Our Ref: GEN/23/01041  
Direct Line: (023) 023 9244 6546  
Ask For: Mrs R McMurray  
Email: [planning.development@havant.gov.uk](mailto:planning.development@havant.gov.uk)

**Site Location:** Church House, The Pallant, Havant, PO9 1BE  
**Re:** Replacement of 2no. ground floor windows

1 X Sliding Sash - W01

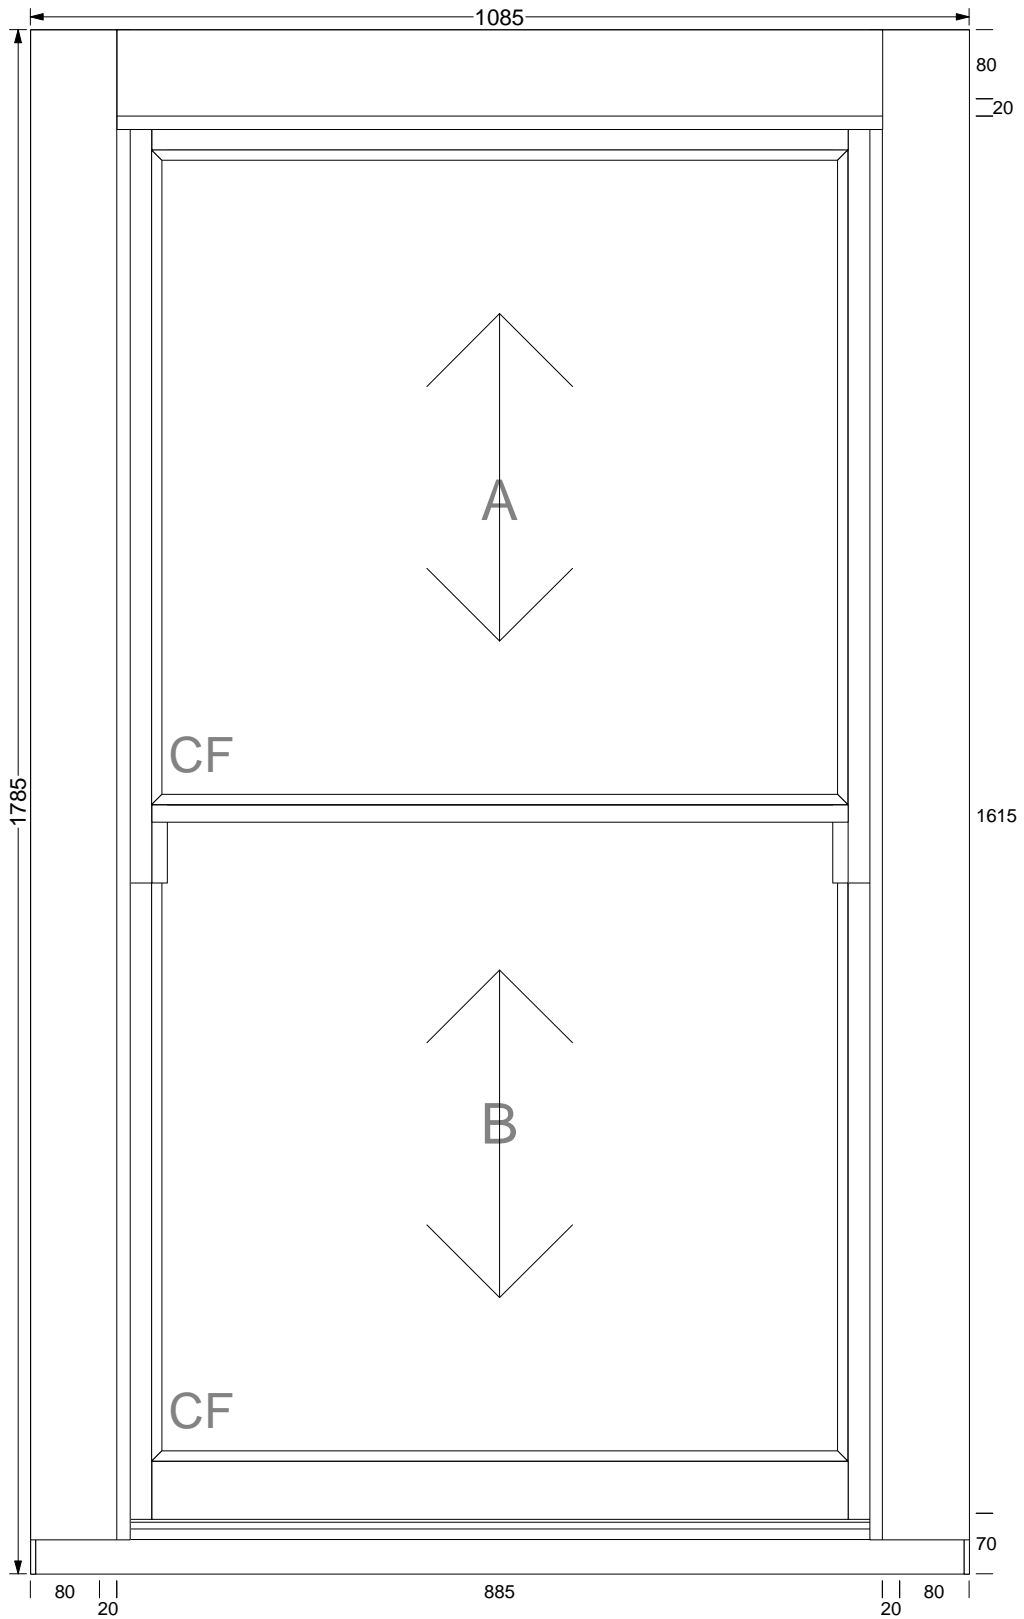
As it appears the windows have been replaced at some point in history, there is more scope to include double glazing in the replacement versions. However, so that this can as closely replicate a historic window as possible, I would advise that this is the slim line style double glazing with a minimum thickness of 6-4-6mm. It is now possible to get slimmer versions than this so if possible, please explore if this is viable in terms of costs for you.

I also advise that the style of the existing windows should be replicated (one over one) and include any decorative mouldings or horns, as this would be in character with the majority of the other windows on the Pallant and rear car park elevations.
